Department of Primary Industries

OUT13/17681

Wallarrah 2 Coal Project (SSD 4974) Response to exhibition of Environmental Assessment

I refer to your email dated 24 April 2013 requesting advice from the Department of Primary Industries (DPI) in respect to the above matter.

Figure 3: Conceptual Project layout: Tooheys Road Site.

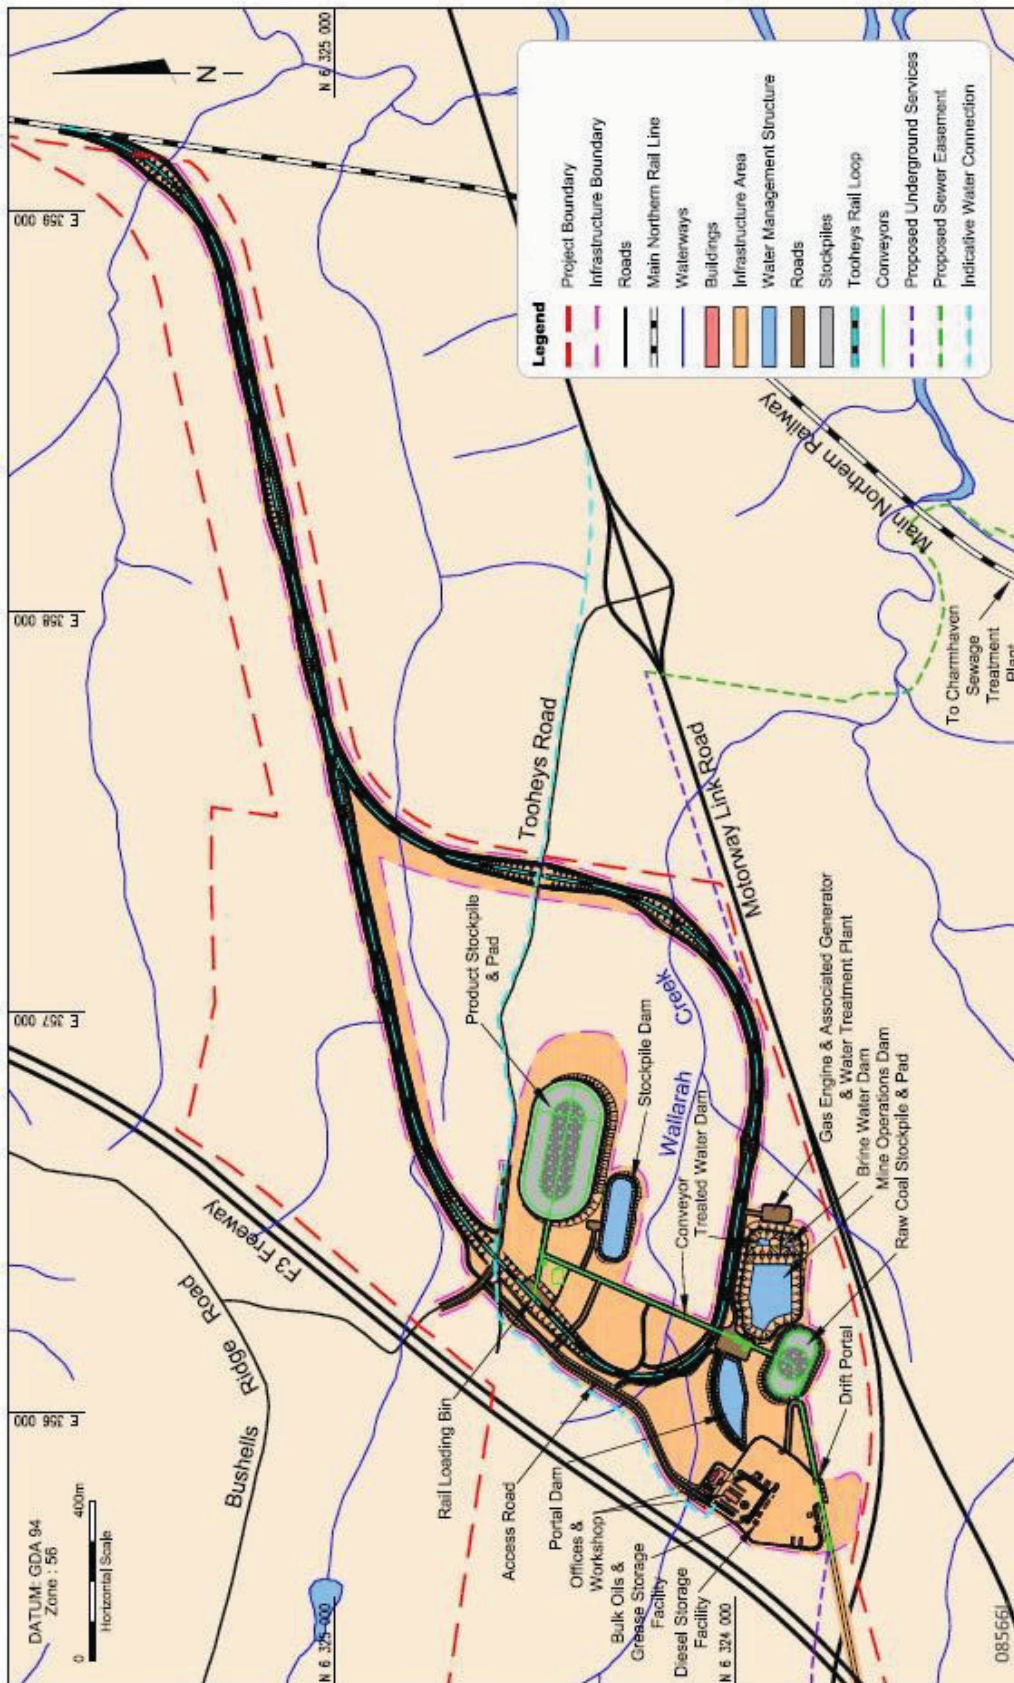
Crown Lands advise that the surface constructions for the Project at Tooheys Road appear to affect Crown public road at the Tooheys Road/F3 intersection. Should this be the case then acquisition of the affected Crown land will be required.

Figure 5: Conceptual Project layout: Western Ventilation Shaft and the Subsidence Impact Limit.

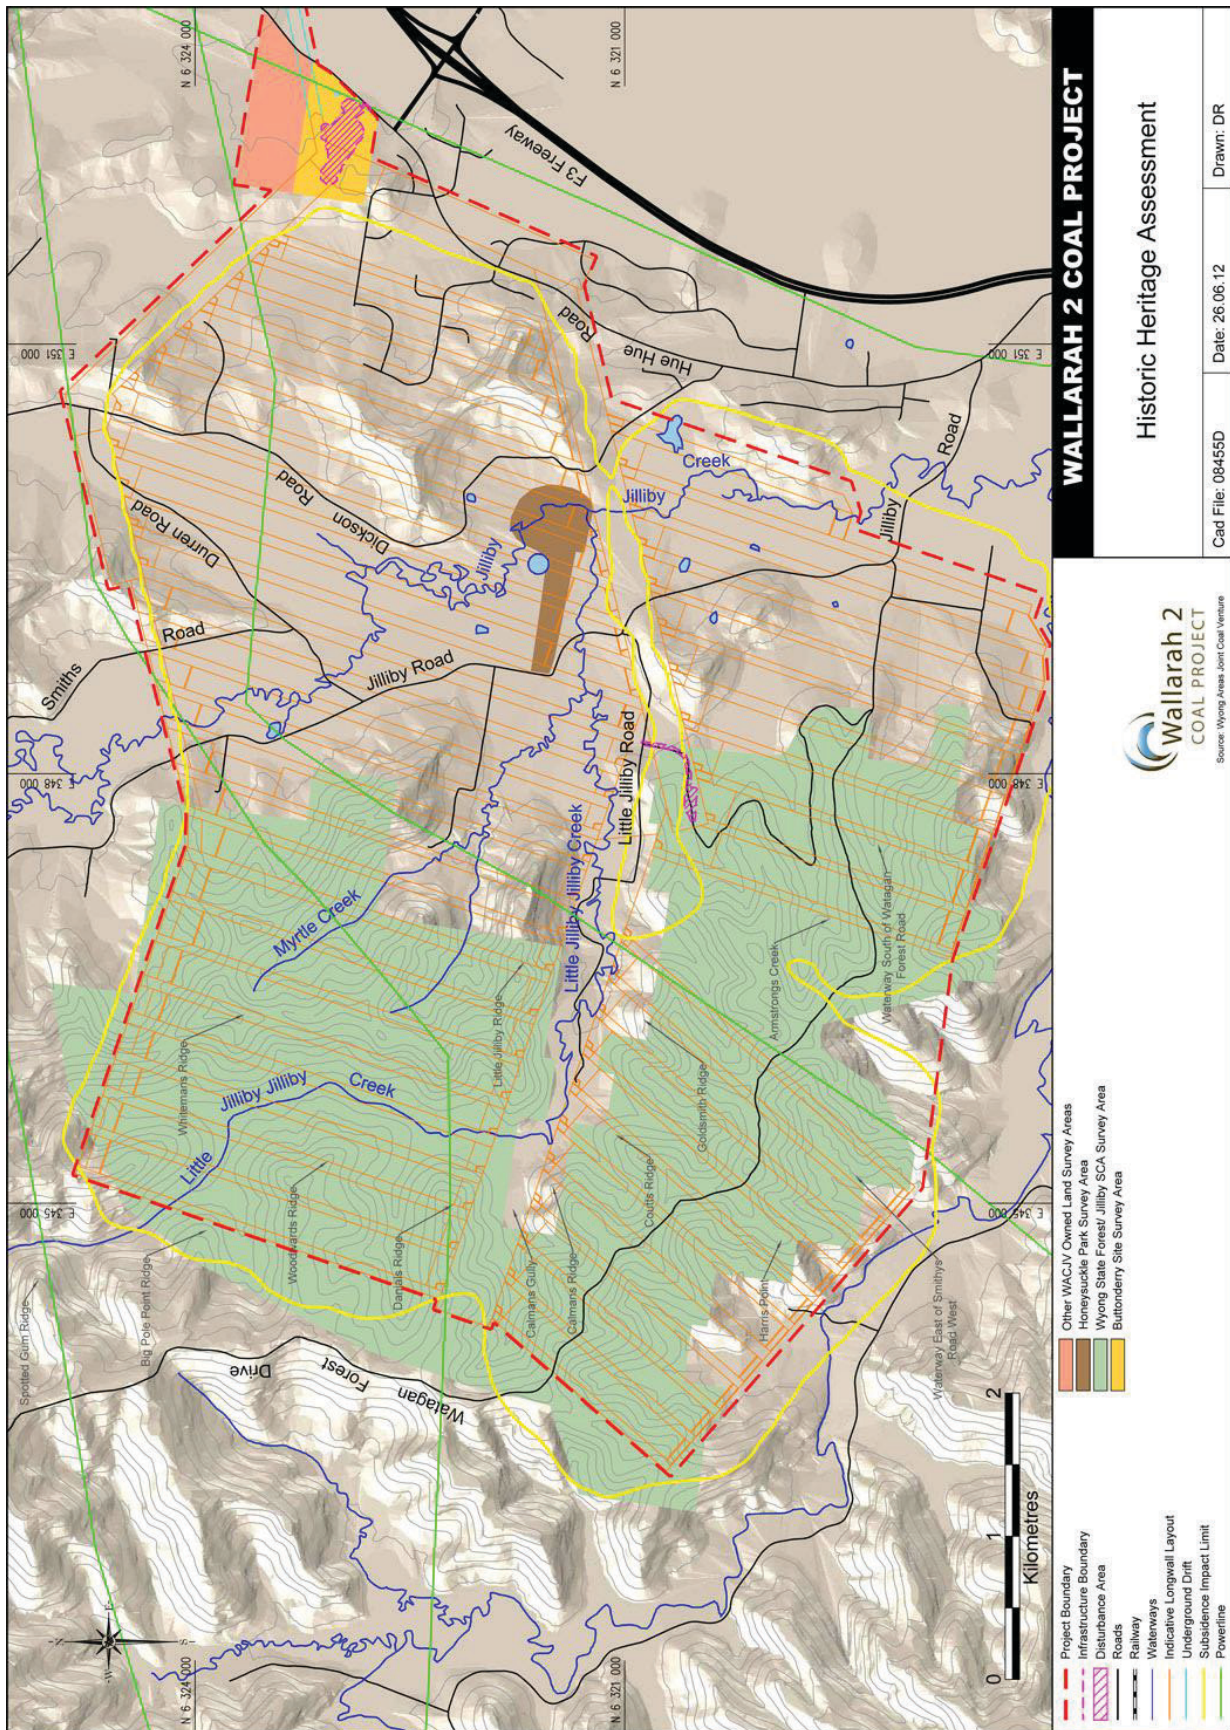
- (b) the western ventilation shaft is proposed for location within Wyong State forest. The text asserts it is already there. The land is owned by the State of NSW. Forestry Corporation NSW is the land manager under the provisions of the *Forestry Act 2012* (refer section 2.5).
